TERLING AND FAIRSTEAD PARISH COUNCIL

18/08/2022

Longfield Solar Energy Farm (application no EN010118) -Interested Party reference 20031557

This is Terling and Fairstead Parish Council's (T&FPC) response to applicant's comments on Relevant Representations (RRs) included at Pages 8-14, using the same order as in the applicant's response.

Figure 2-12

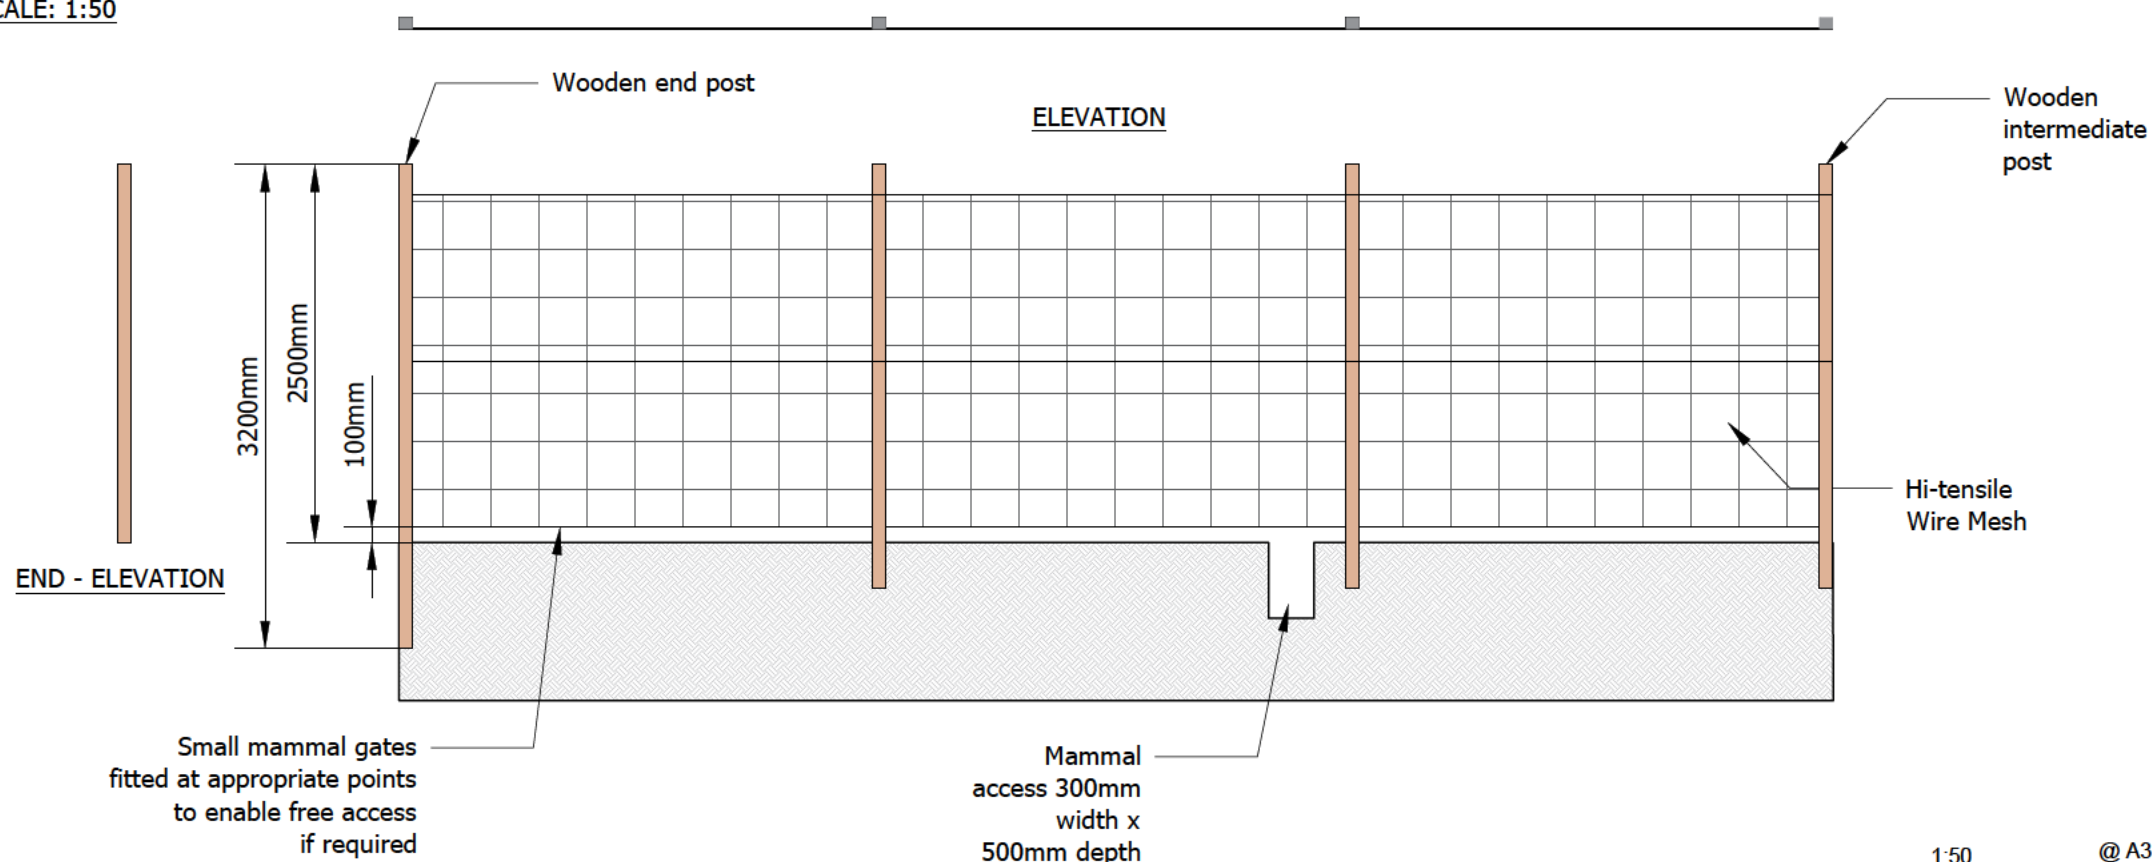
The applicant's position is noted. The EA is requested to consider the size of the proposal, its ground coverage, the BESS, associated fencing and infrastructure. The efforts and proposals to mask the impact by landscape design are limited. There could easily be community assets designed into the scheme, eg cycle routes, to further mitigate its intrusion, in effect the applicant is proposing a gated and deer-fenced industrial complex and BESS.

The perimeter use of high-level CCTV, floodlighting and on-site security further demonstrates it is an industrial plant complex.

Battery Container Elevation and Plan View

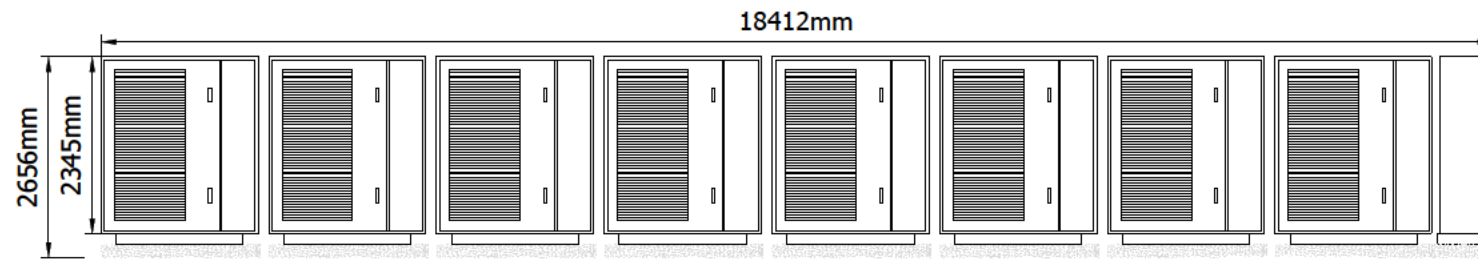
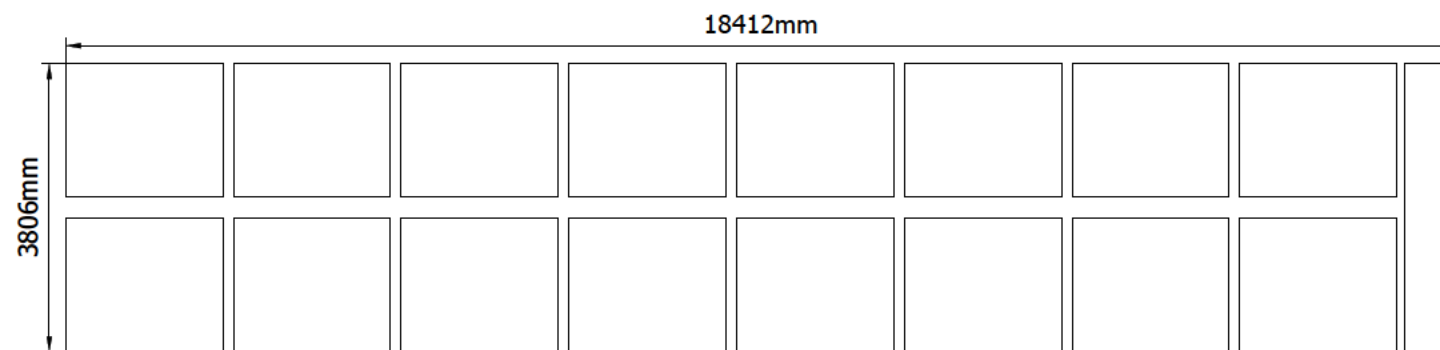
The lithium ion technology proposed has inherent stability issues as evidenced by explosions both overseas and in the UK. We are told the BESS facility will be remotely monitored.

We are still to be convinced that the size of the BESS at scale (which we understand is to be the largest in the UK) and that the associated risks are low as the applicant claims.

Figure 5: Proposed Order limits Access Arrangements (Construction Phase)

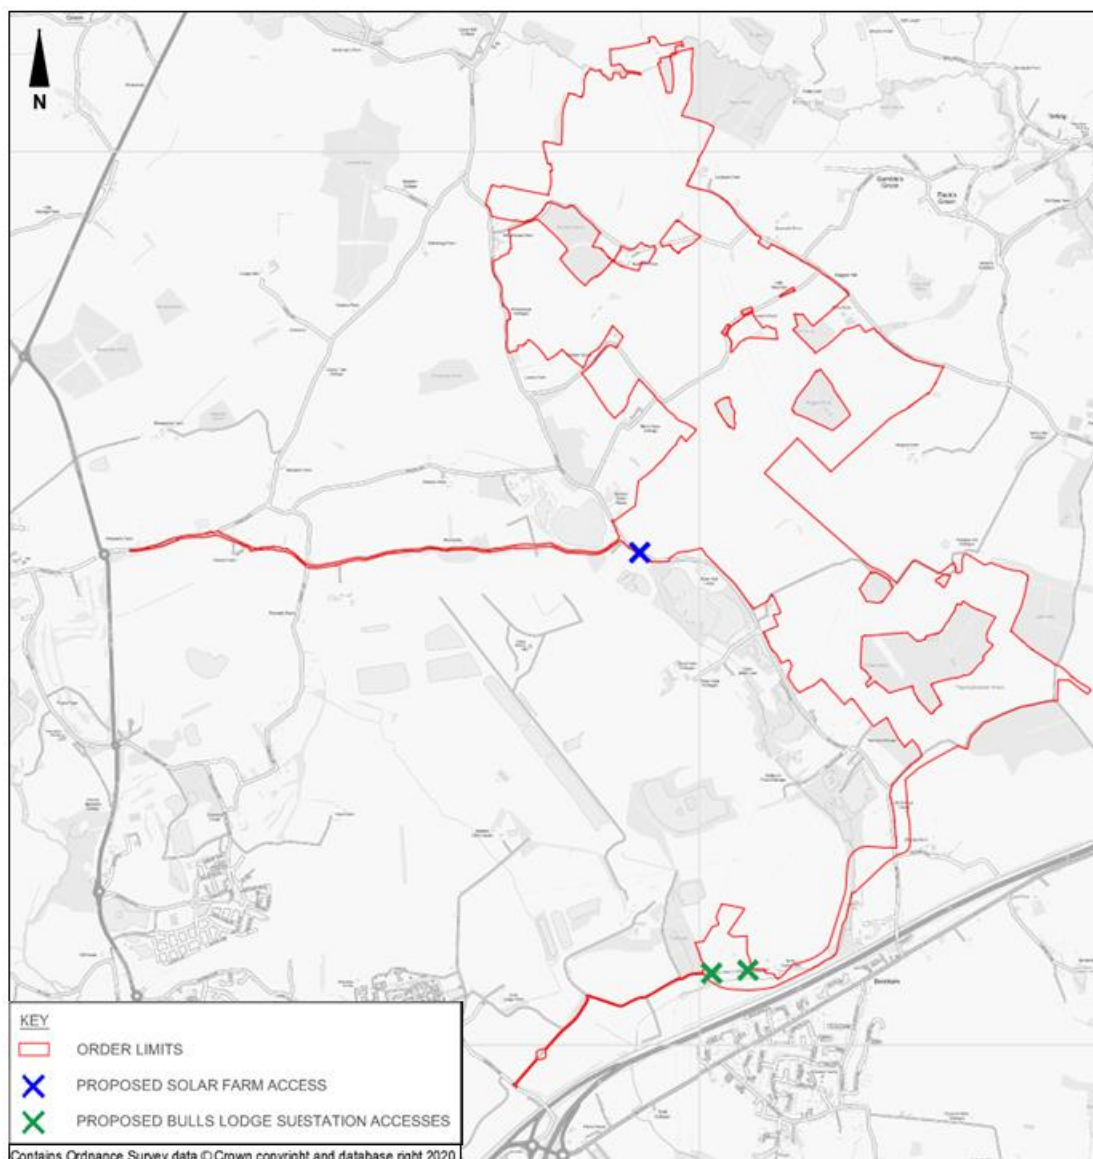
We note the proposed roadworks to provide access to the scheme. Are these improvements to be permanent and to adoptable standards? Are there set to be any weight limits or hours of operation?

Will the speed limit be 30mph? (even 20mph). Presently the roads are not restricted so speed of 60mph is the upper speed limit on these very constrained roads.
